KITTITAS COUNTY

MEMORANDUM

SUBJECT: Strole Ag Short Plat SP-15-00009

**STROLE AG SHORT PLAT SS - XX-XX
PREPARED FOR
JEFF STROLE**
A PORTION OF THE W 1/2 OF SECTION 35
TOWNSHIP 19 N., RANGE 18 E., W.M.

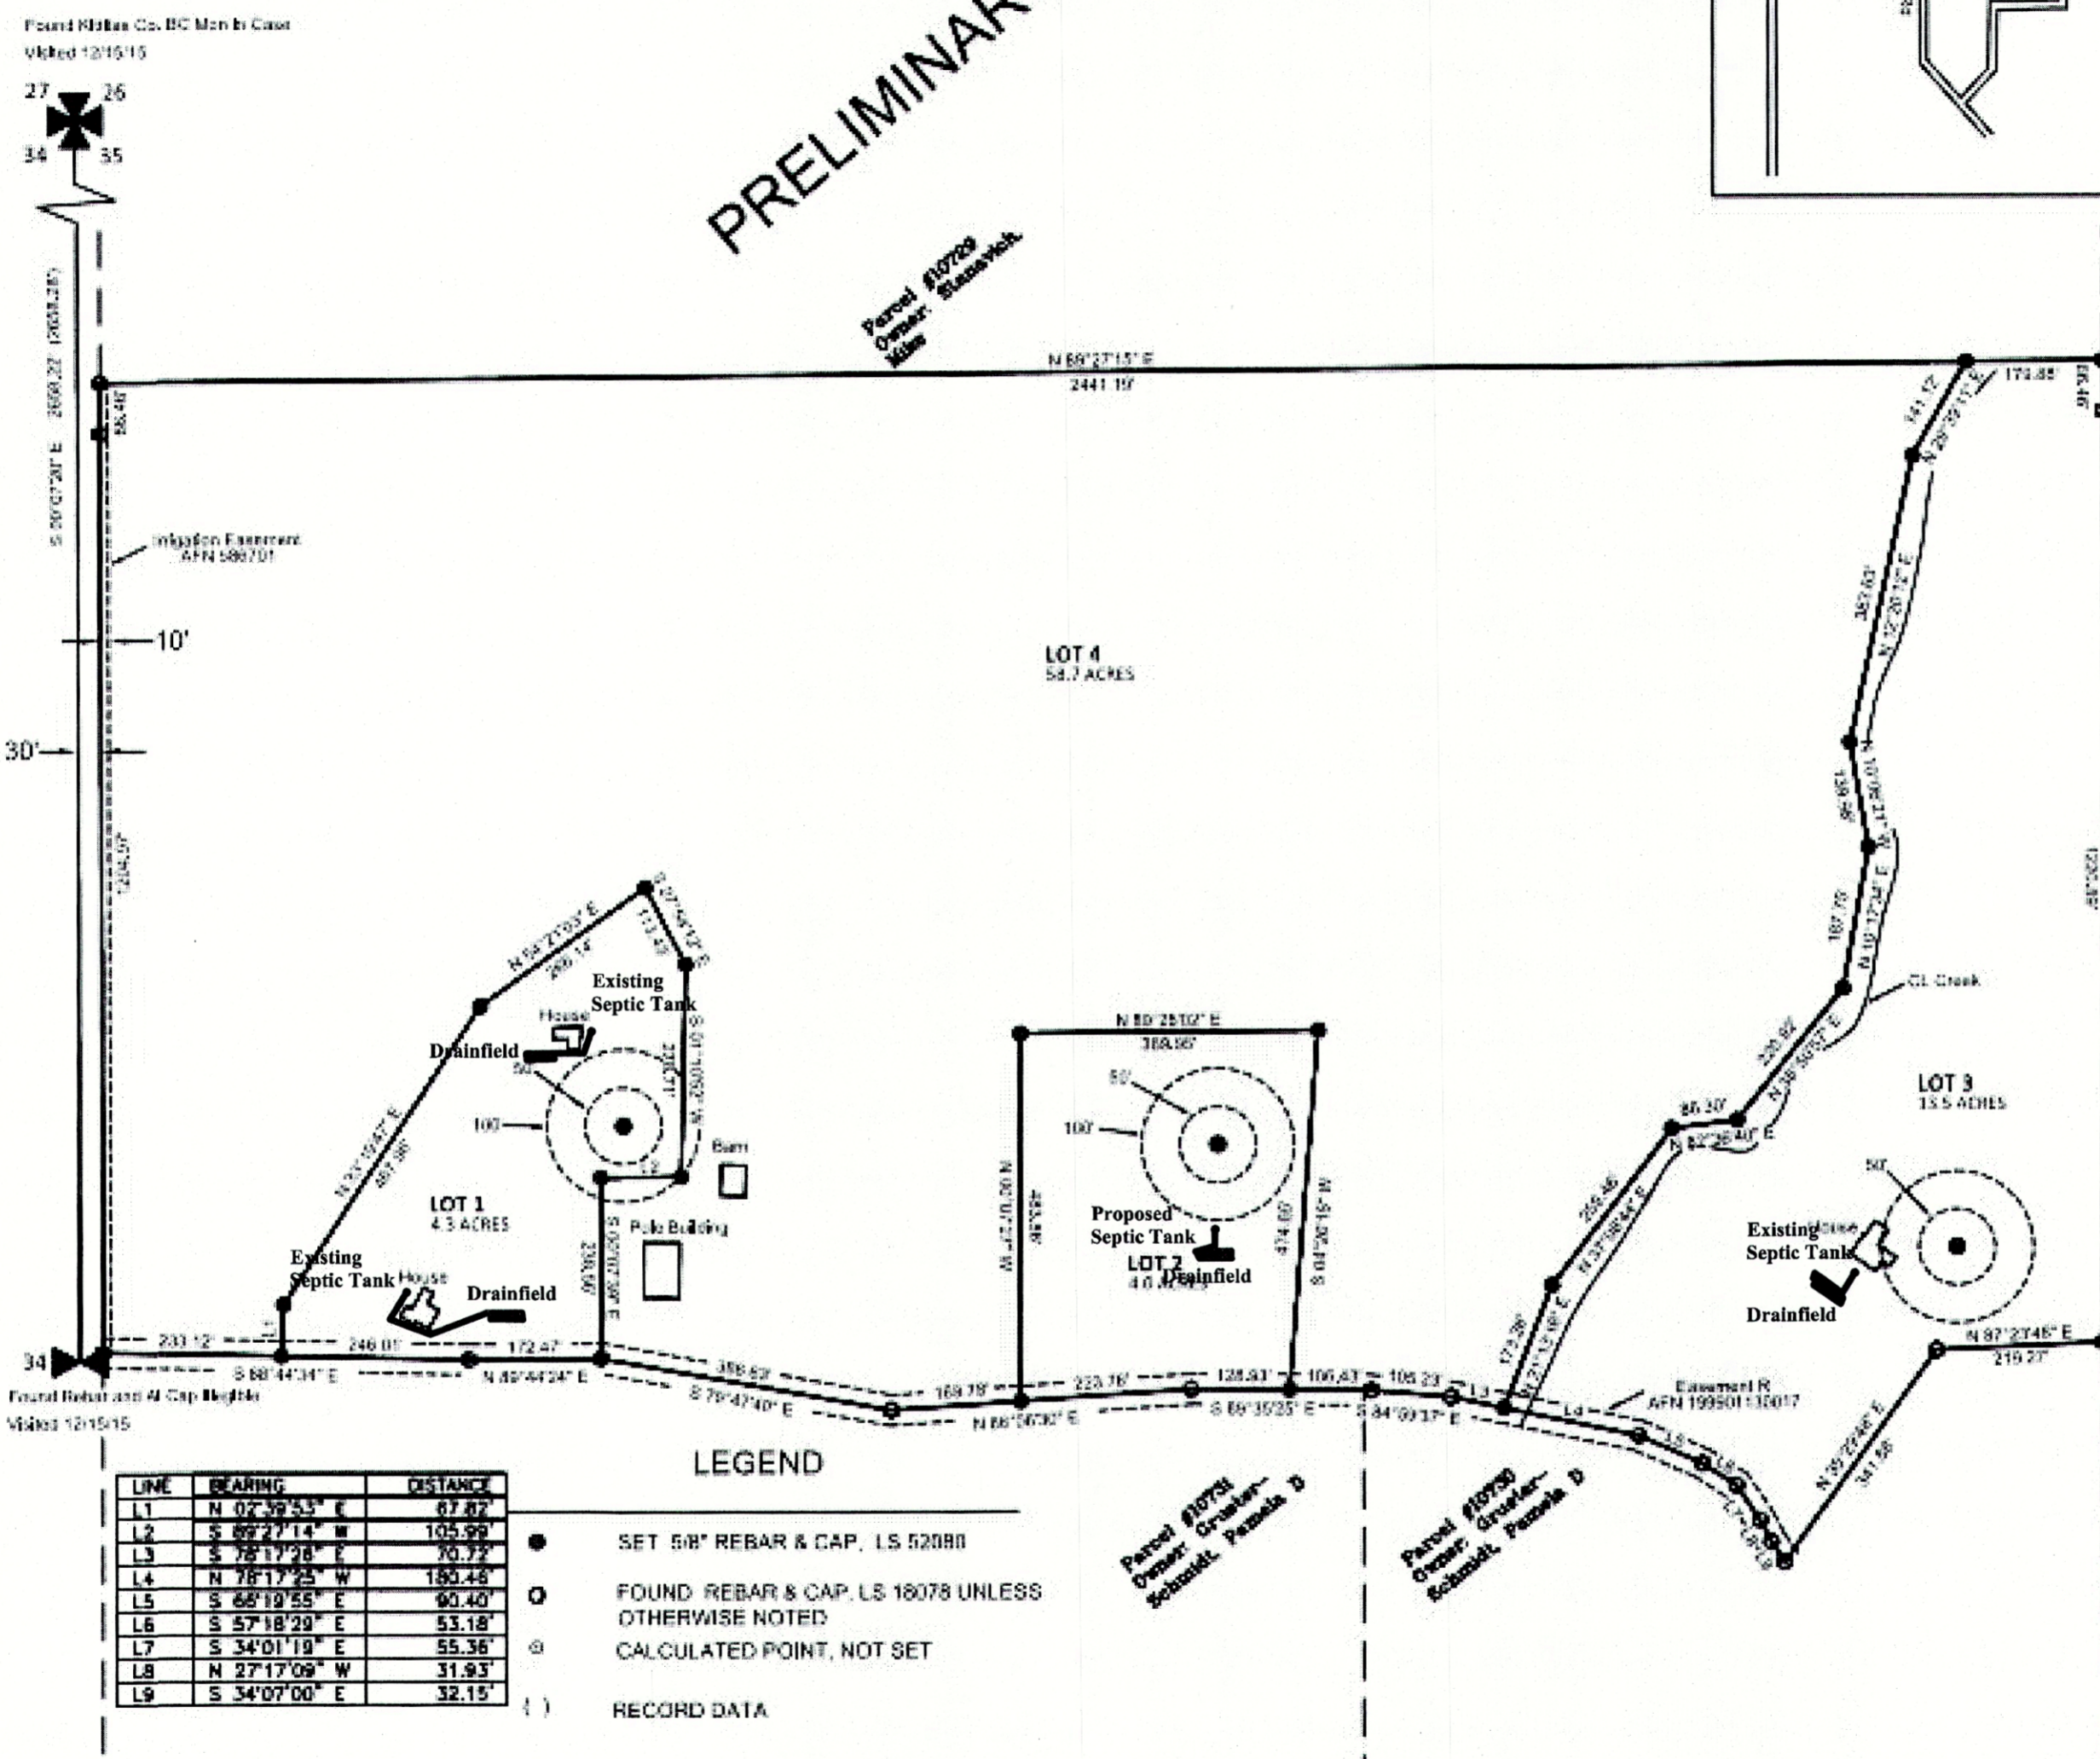
1. Floodplain: Needs to be depicted on the face of the Short Plat
2. Timing of Improvements: This application is subject to the latest revision of the Kittitas County Road Standards, dated 12/15/15. The following conditions apply and must be completed prior to final approval of this project. A performance guarantee may be used, in lieu of the required improvements, per the conditions outlined KCC12.01150.

4. Private Road Improvements: Access from Robbins Road shall be constructed as a Low-Density Private Road. See Table 4-4, current Kittitas County Road Standards, 12/15/15 edition.

- a. Access easements shall be a minimum of 60' wide. The roadway shall have a minimum width of 20', with 1' shoulders, for a total width of 22'.
 - b. Minimum centerline radius will be 60'.

- c. The surface requirement is for a minimum gravel surface depth of 6".
 - d. Maximum grade is 10%.
 - e. Stopping site distance, reference AASHTO.
 - f. Maintenance of driveway approaches shall be the responsibility of the owner whose property they serve. The County will not maintain accesses.

- i. All easements shall provide for AASHTO radius at the intersection of county road.
 - j. A paved apron shall be constructed at the intersection of the proposed private intersection and the county road right of way.

6. Turnaround: When a road extends more than 150' from the centerline of a County road or other publicly maintained road or serves more than three lots, a turnaround shall be provided. The turnaround shall be a cul-de-sac for roads serving five or more lots/units. The turnaround may be a hammerhead for roads serving four or less lots/units or for a land use development activity occurring prior to the end of the road. Cul-de-sac and hammerhead designs must conform to the specifications of the International Fire Code. A cul-de-sac shall have an easement diameter of at least 110 feet and a driving surface of at least 96 feet in diameter.
